**Sydney Children's Hospital Stage 1 and Children's Comprehensive Cancer Centre  
(SSD-10831778)**

Thank you for your correspondence via the Major Projects Portal on 17 May 2021, requesting Transport for NSW (TfNSW) to review and comment on the above.

Drawing Title
**Turning Paths
Vehicle access to SCH1/CCCC B02
car park**

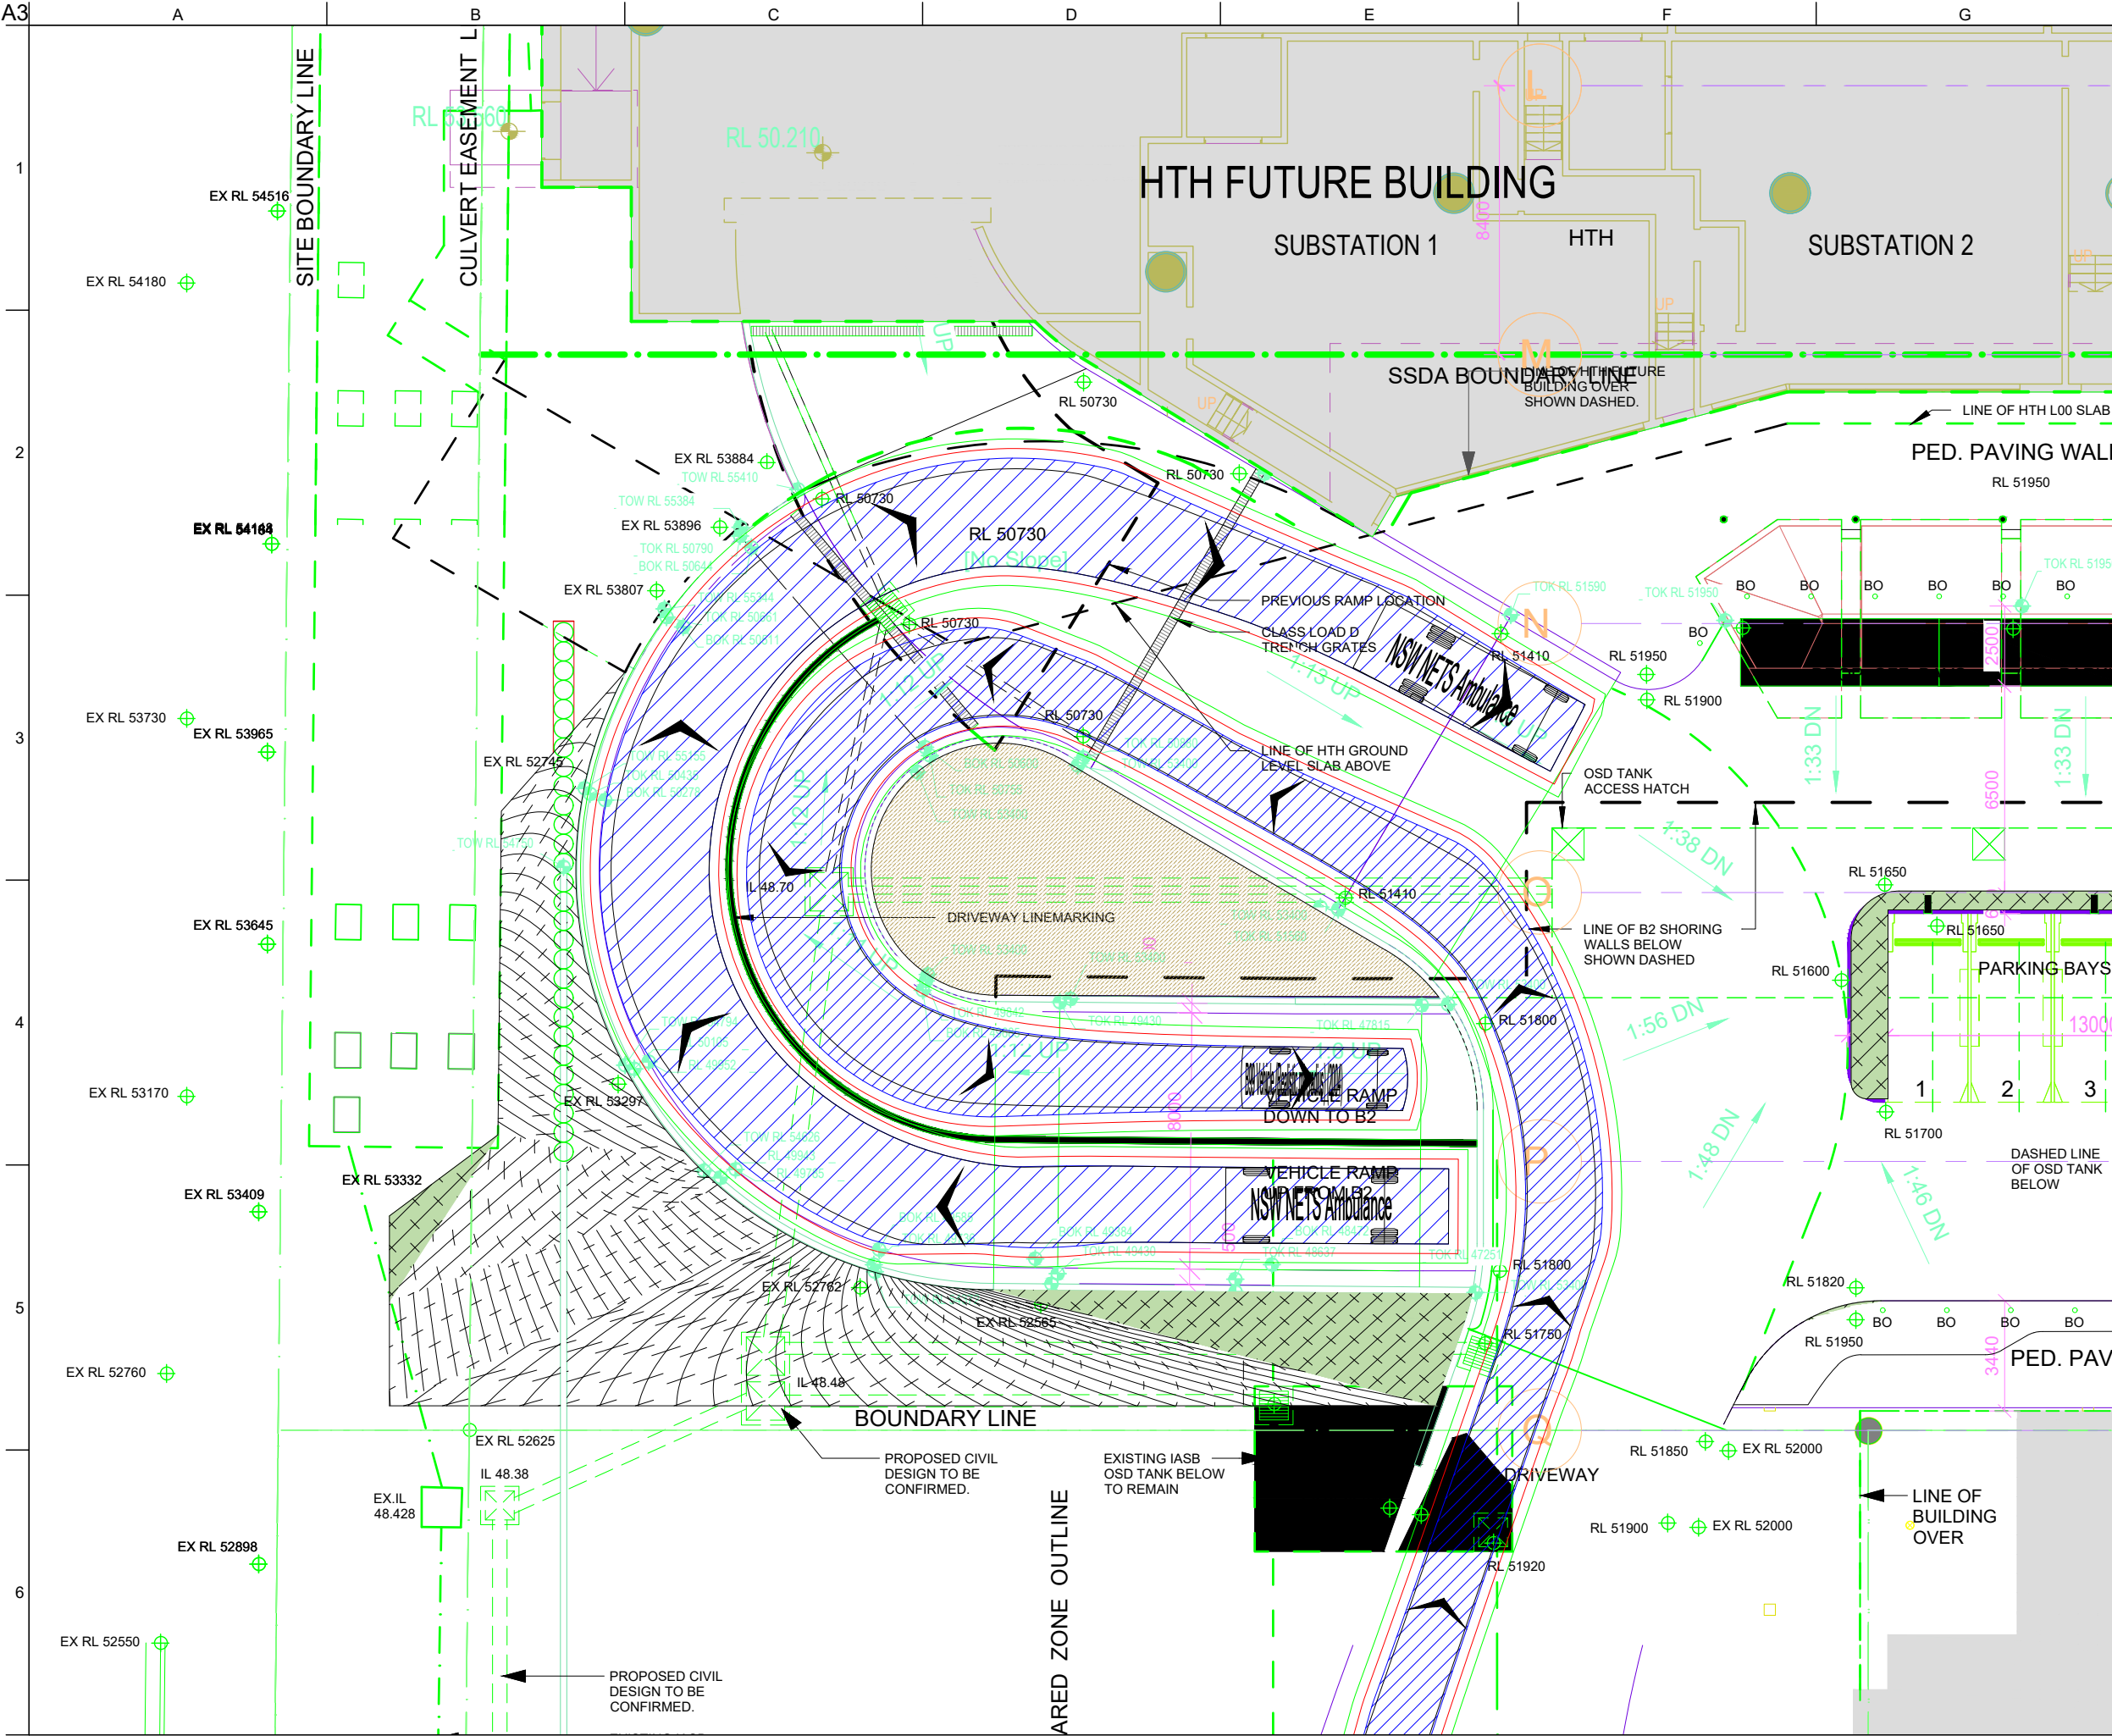
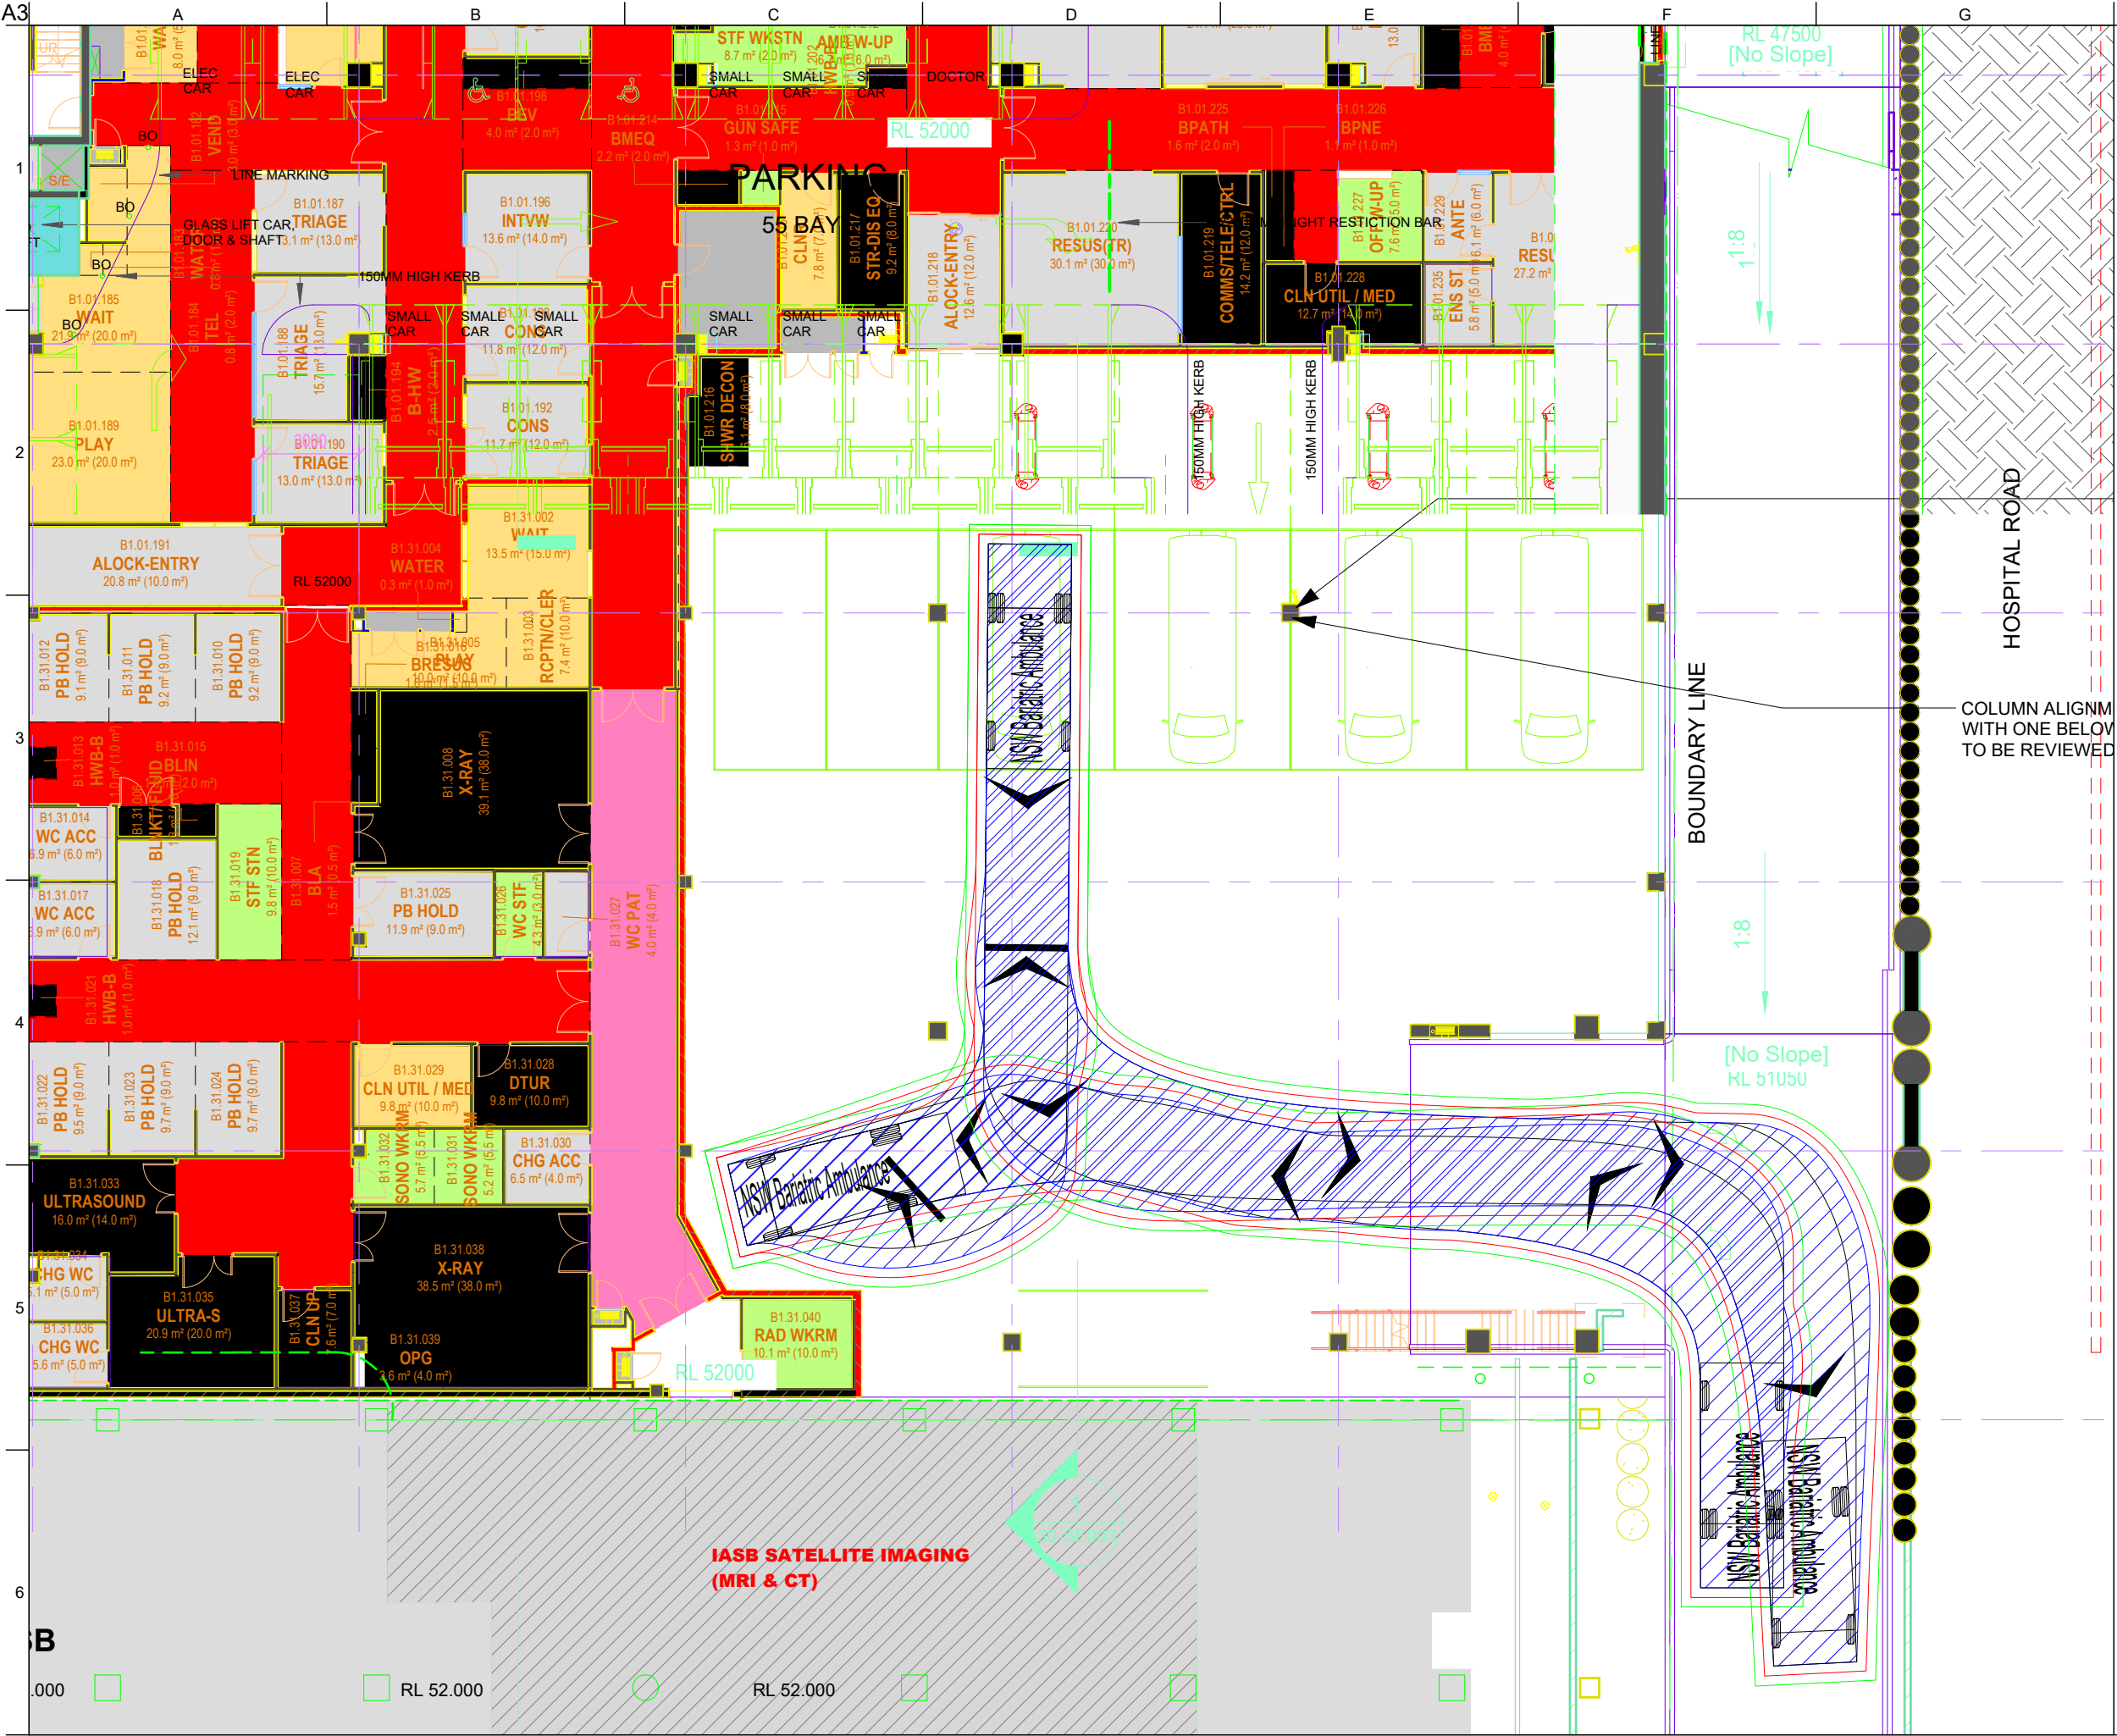
Swept paths analysis has not been undertaken for the maximum size of the vehicle accessing the loop road (Ambulances) via Botany Street in the Traffic and Transport Assessment.

- Consider providing a consolidated loading dock for the subject site as well as the Children's Hospital Stage 1 and Children's Comprehensive Cancer Centre with access via Hospital Road. This is to remove the heavy vehicle access via Botany Street;
- A Stage 2 (Concept Plan) Road Safety Audit for the proposed vehicle and pedestrian access arrangement to the subject site in accordance with *Austroads Guide to Road Safety Part 6: Managing Road Safety Audits* and *Austroads Guide to Road Safety Part 6A: Implementing Road Safety Audits* by an independent TfNSW accredited road safety auditor; and
- A swept path analysis for the maximum size of the vehicle (Ambulances) entering and leaving the loop road to / from Botany Street.
